**RE: Westgate Community Center  
10001 DeVargas Rd SW  
Grading and Drainage Plan  
Engineer's Stamp Date: 8/12/19  
Hydrology File: M09D030**

Based on the submittal received on 8/14/19, the Grading and Drainage Plan cannot be approved until the following corrections are made:

DRAINAGE MANAGEMENT PLAN

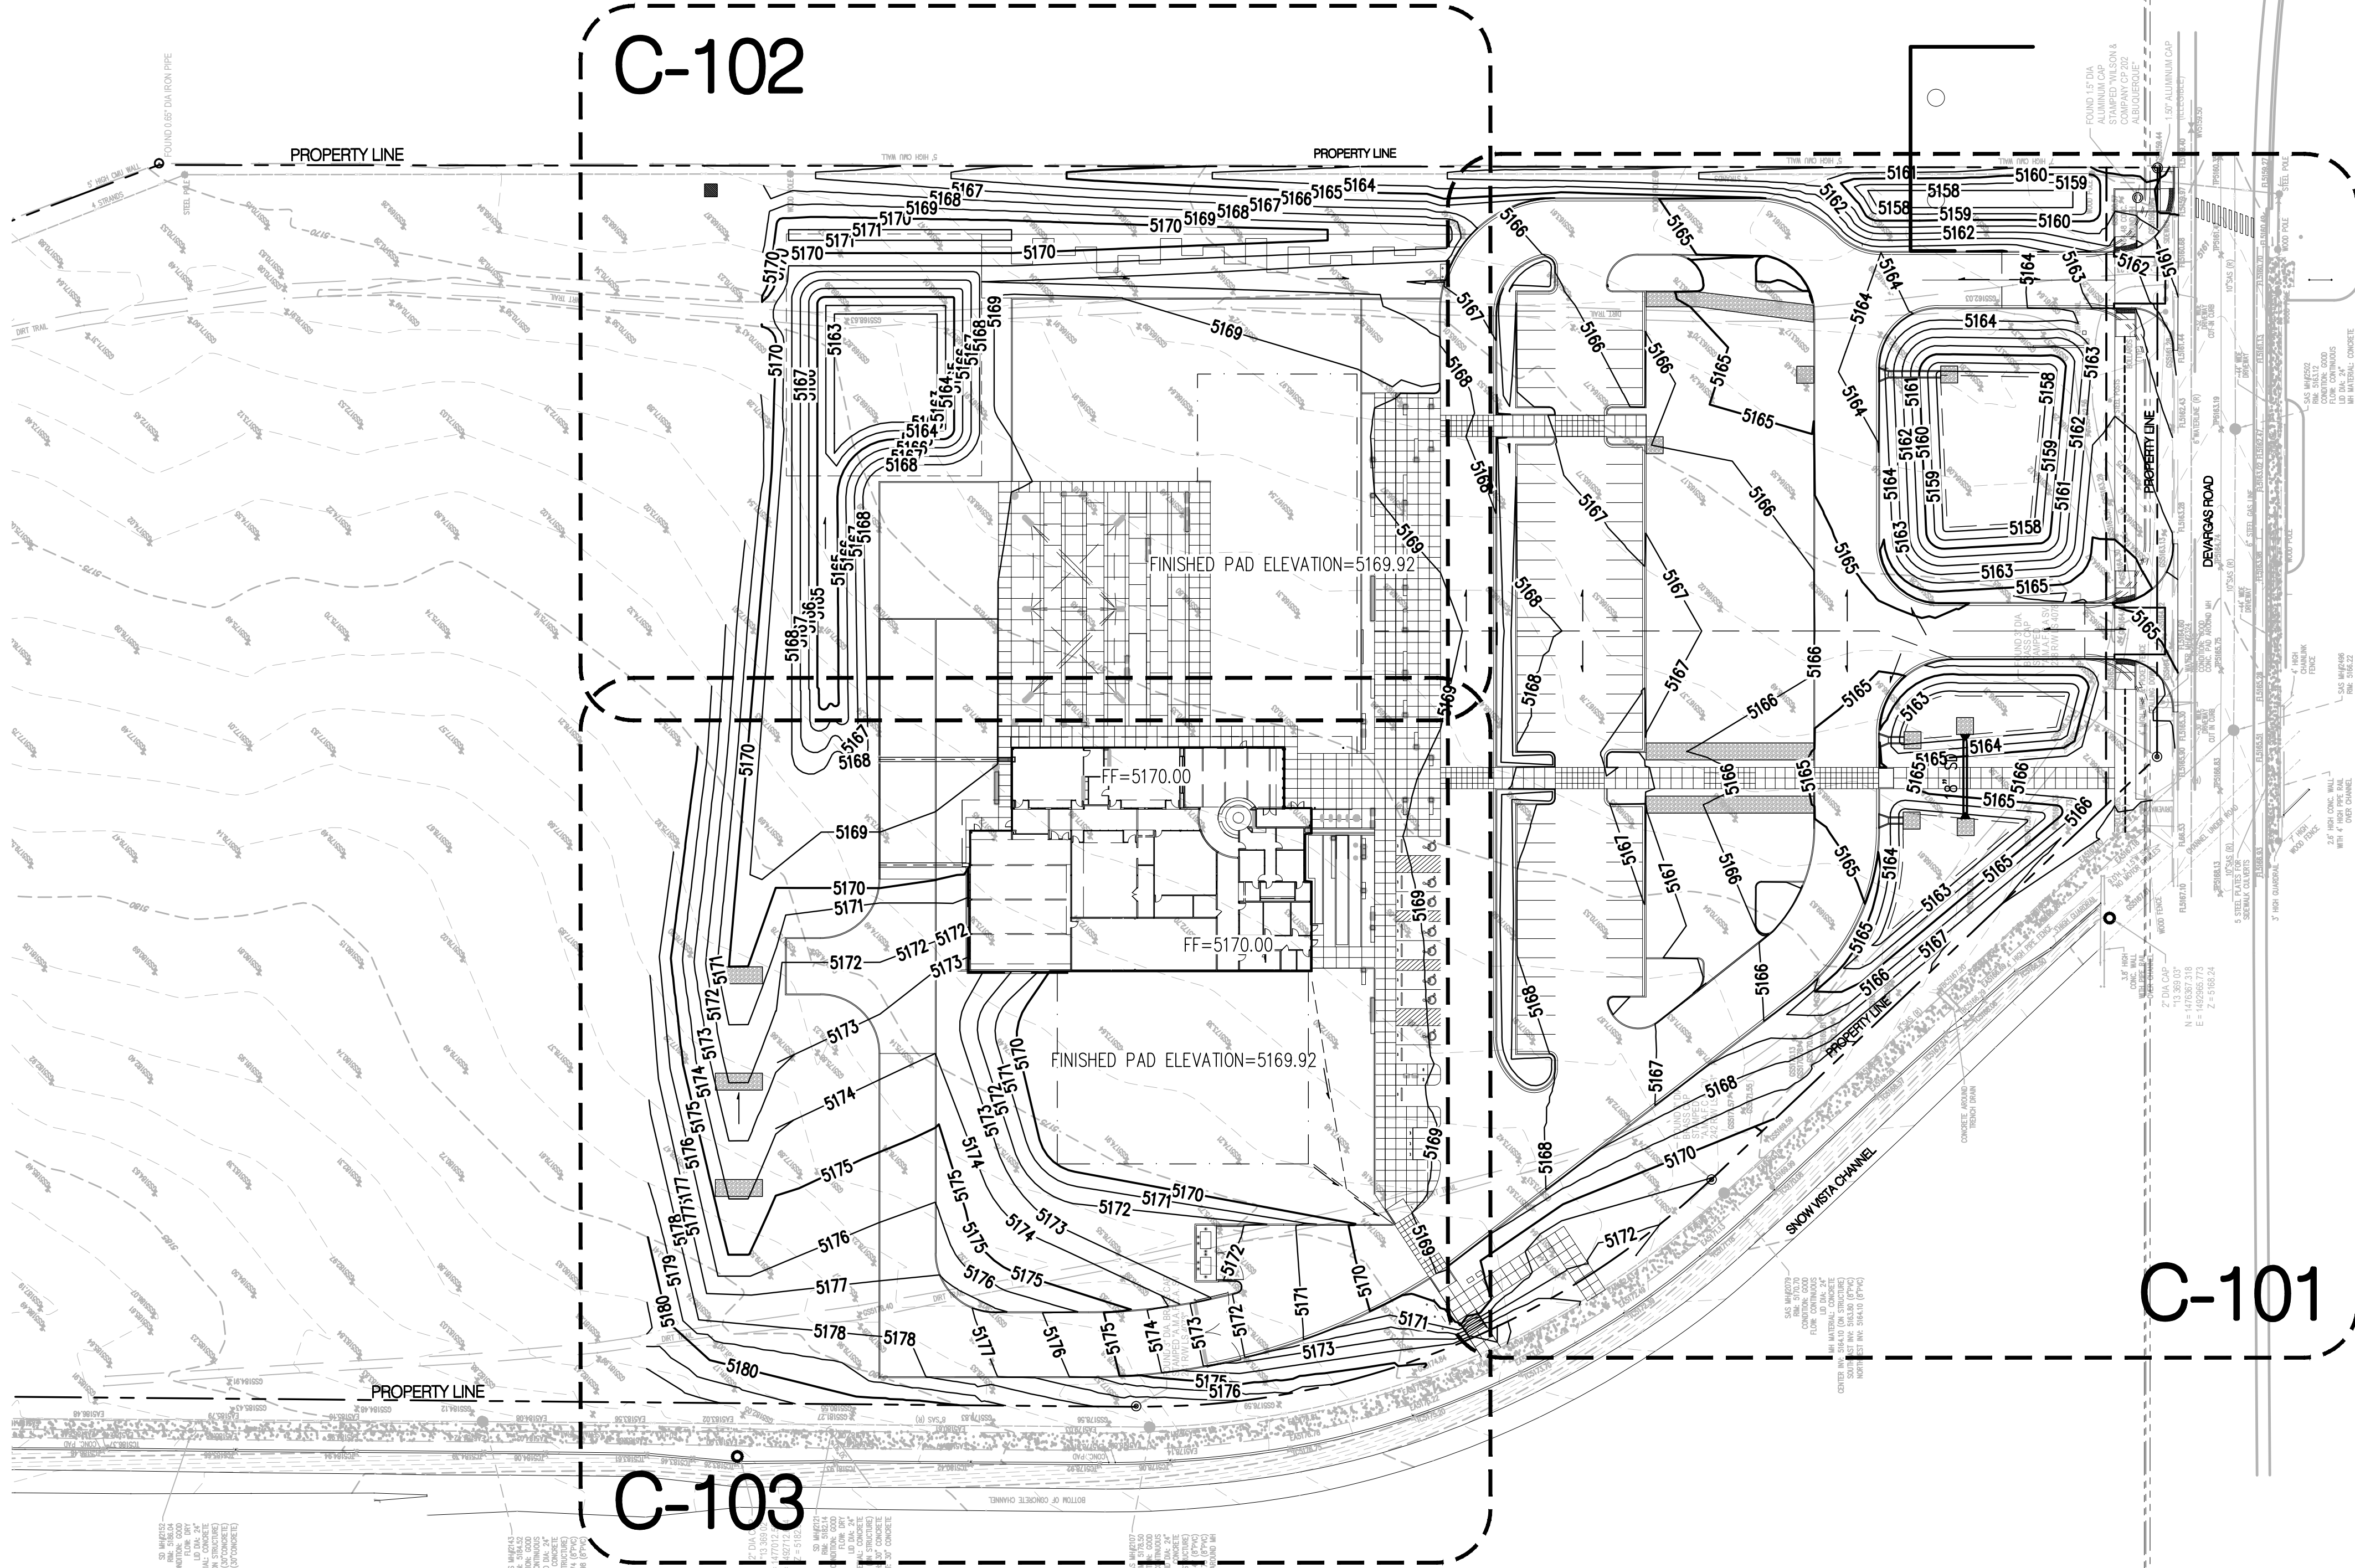
1. Provide hydraulic calculations for the riprap swale along the north side of the project; and calculations from Pond 1 back on the plan.
2. Put the concrete swale (emergency overflow) from pond 1 back on the plan. Any alternative design needs to be designed and stamped by a professional engineer and provided on the stamped grading plan.

3. Put the riprap swale into pond 1 back on the plan. Any alternative design needs to be designed and stamped by a professional engineer and provided on the stamped grading plan.

4. Put the riprap swale along east property line back on the plan. Any alternative design needs to be designed and stamped by a professional engineer and provided on the stamped grading plan.

5. Provide an armored swale and slope stabilization around the western future building pad. Put the retaining wall section (former section A-A) back on the plan for the section of stem wall that is getting built.

7. Will the basin B-2 area be used for staging? It needs to be reseeded if so; specify reseeding per section 1012 for all disturbed areas.
8. Depress the landscaping in the parking islands to provide additional water quality and allow water to enter the islands instead of ponding/ backing up in the parking spots.
9. Screen-back or otherwise annotate what parking islands & curbs will be built now and which are future.
